From: Alan Business [REDACTED]
Sent: 13 October 2017 16:25
To: Daun Johnson
Subject: Re: 29 Willowhale Avenue, Aldwick AW/296/17/HH

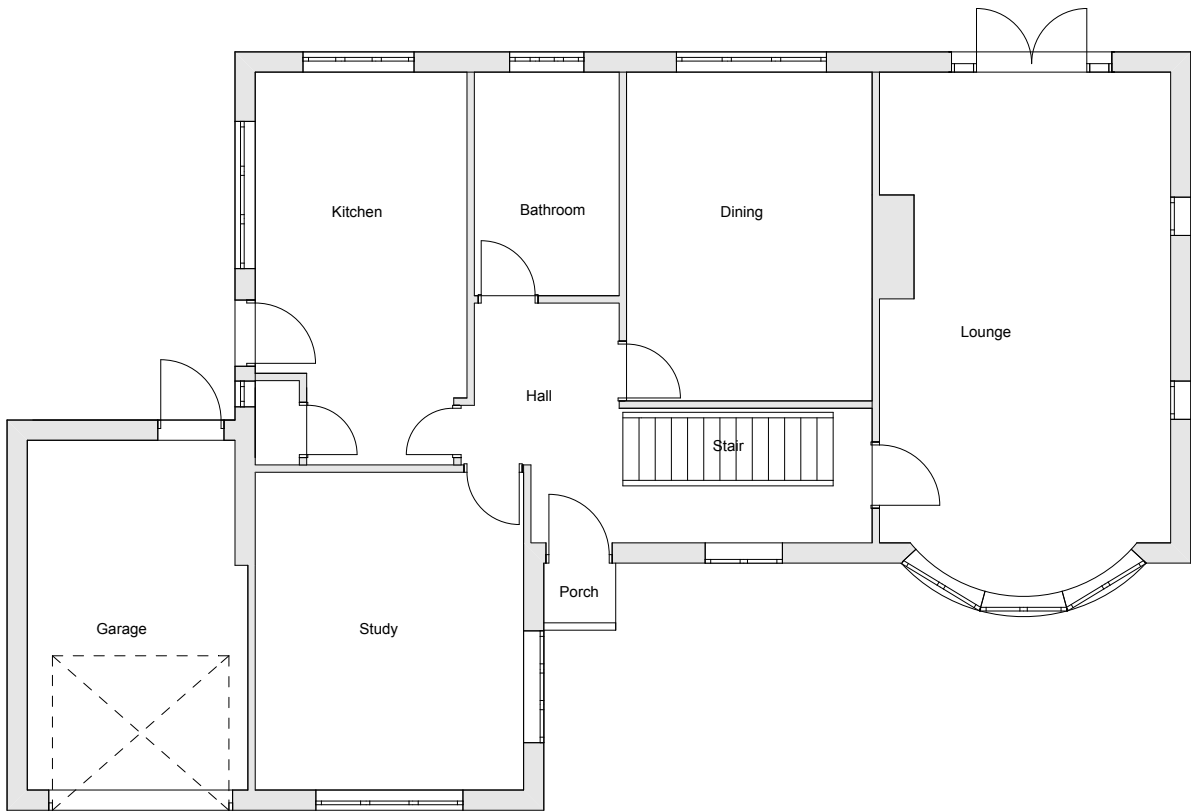
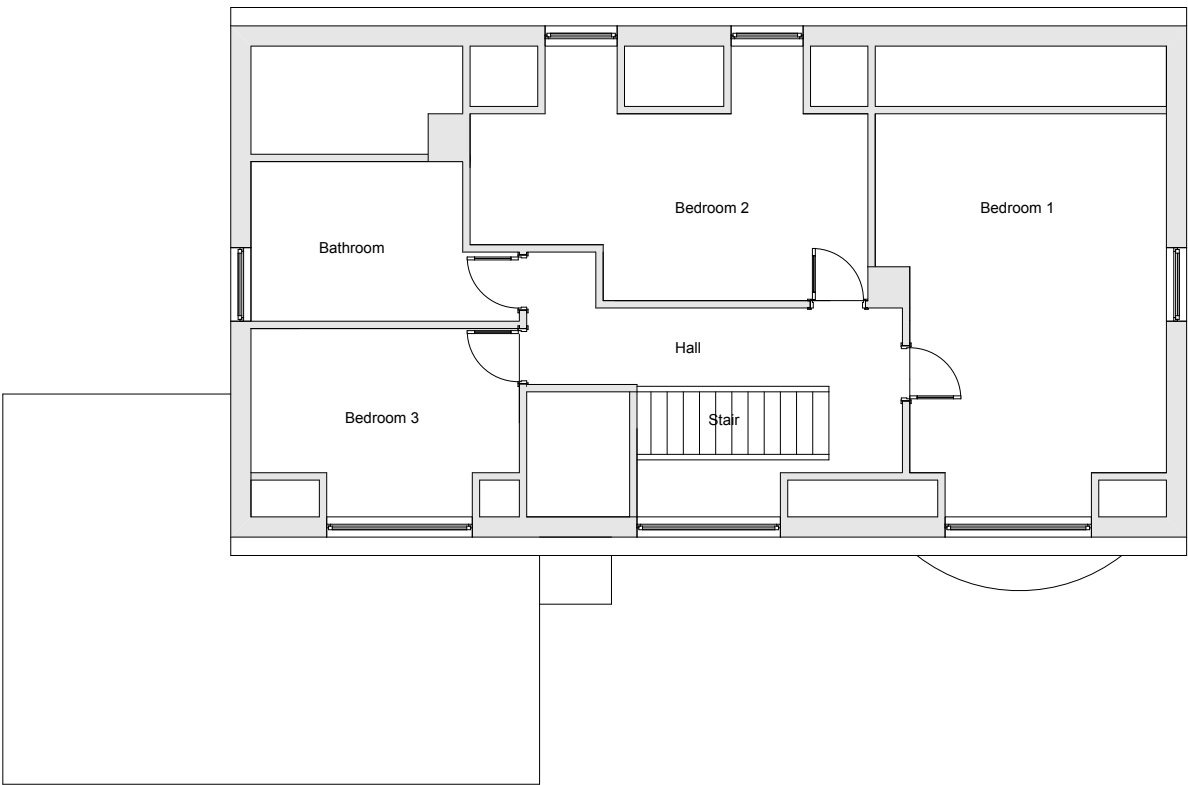
1. On the proposed block plan, please clearly highlight all proposed works and provide measurements from the proposals to the site boundaries.
2. The existing rear and side floor plans at ground floor do not accord with the elevations.
3. I would suggest the amended description to the application: 'Remodelling of roof to form 4 No. dormers to rear elevation, 2 No. dormers to front elevation and 1 No. dormer to side elevation, front and side extensions'. Please confirm that the amended description is satisfactory.

1. I have amended the Block Plan drawing no. 201, now 201A. i have shaded the new areas and added dimensions to boundaries.
2. I have added the door into the back of the garage and the window and door at the side of the Kitchen and Larder and now enclose amended drawing no. 101A.
3. I am happy with the description that you propose but would observe that the rear elevation has one long dormer with 4 no. windows in it.
